Town and Country Planning Act 1990 Refusal of Planning Permission

Reference: H16-0536-15 Received: 12th June 2015

Description: Proposed extensions including internal alterations to existing dwelling

Location : 12 HALMER GATE SPALDING

E	Additional notes added re neighbours windows	myw	5/6/15
D	Revised to suit elevation drawing 4202/2015	myw	16/5/15
C	Revised to suit clients comments	myw	12/5/15
B	Revised to remove steelwork at first floor	myw	9/5/15
A	Revised to suit clients comments	myw	7/5/15

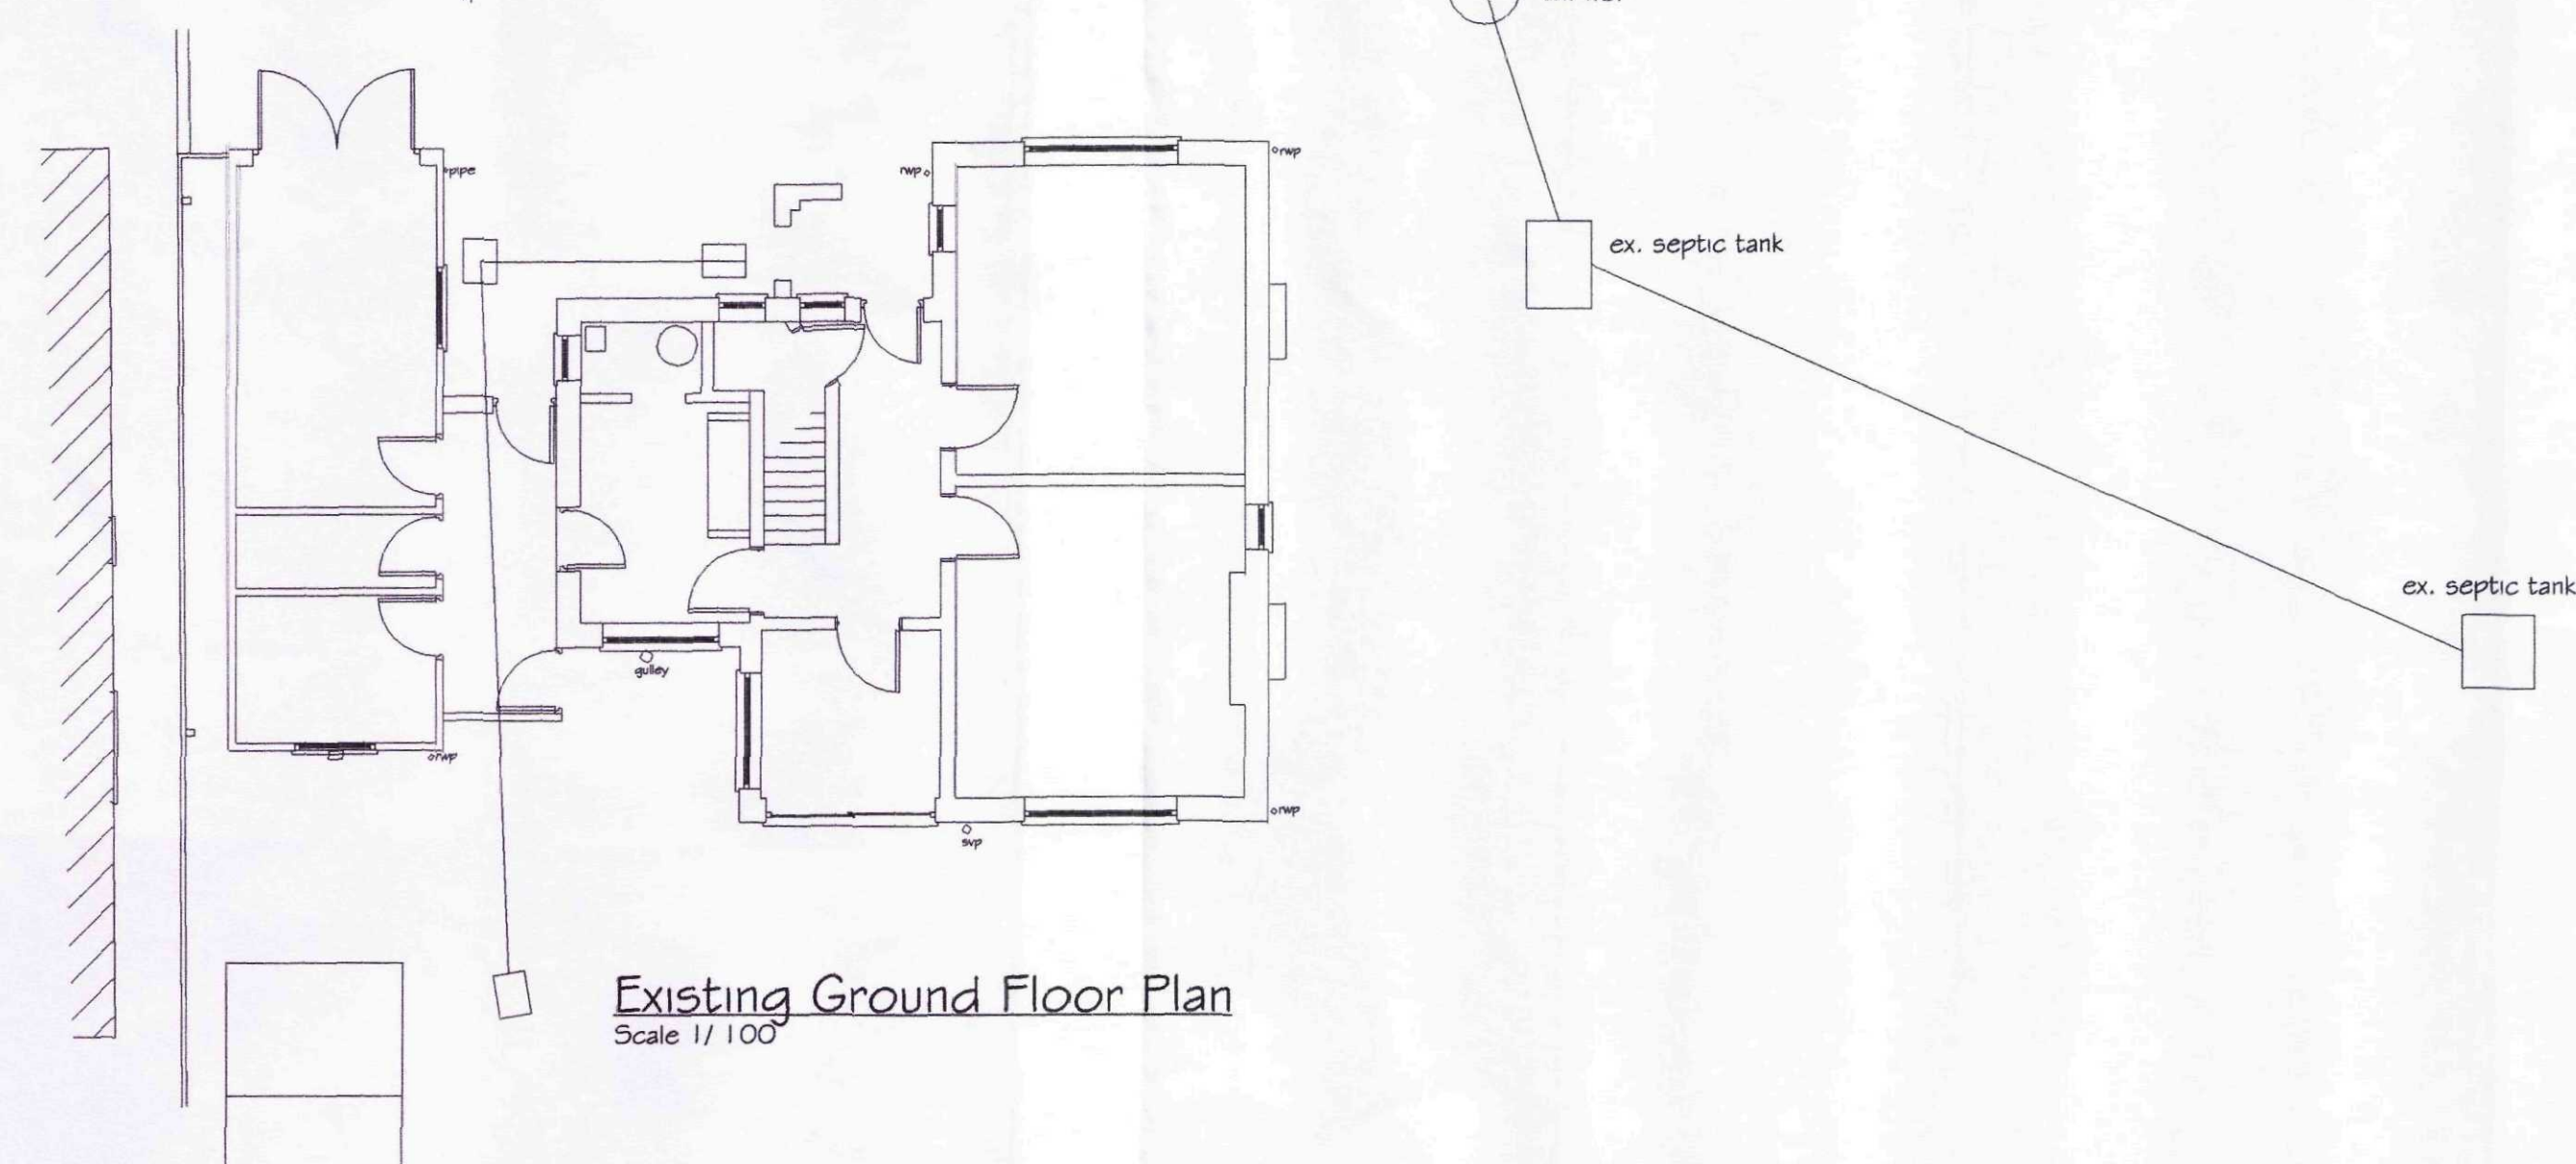
- 1 The proposal would lead to a substantial loss of light to the windows on the side elevation of the adjacent Guest House by virtue of the siting of a two-storey wall 1.9 metres from the existing window. This would be contrary to Policies SG1 and SG20 of the South Holland Local Plan, 2006. which seek to protect the amenities of adjacent residents.
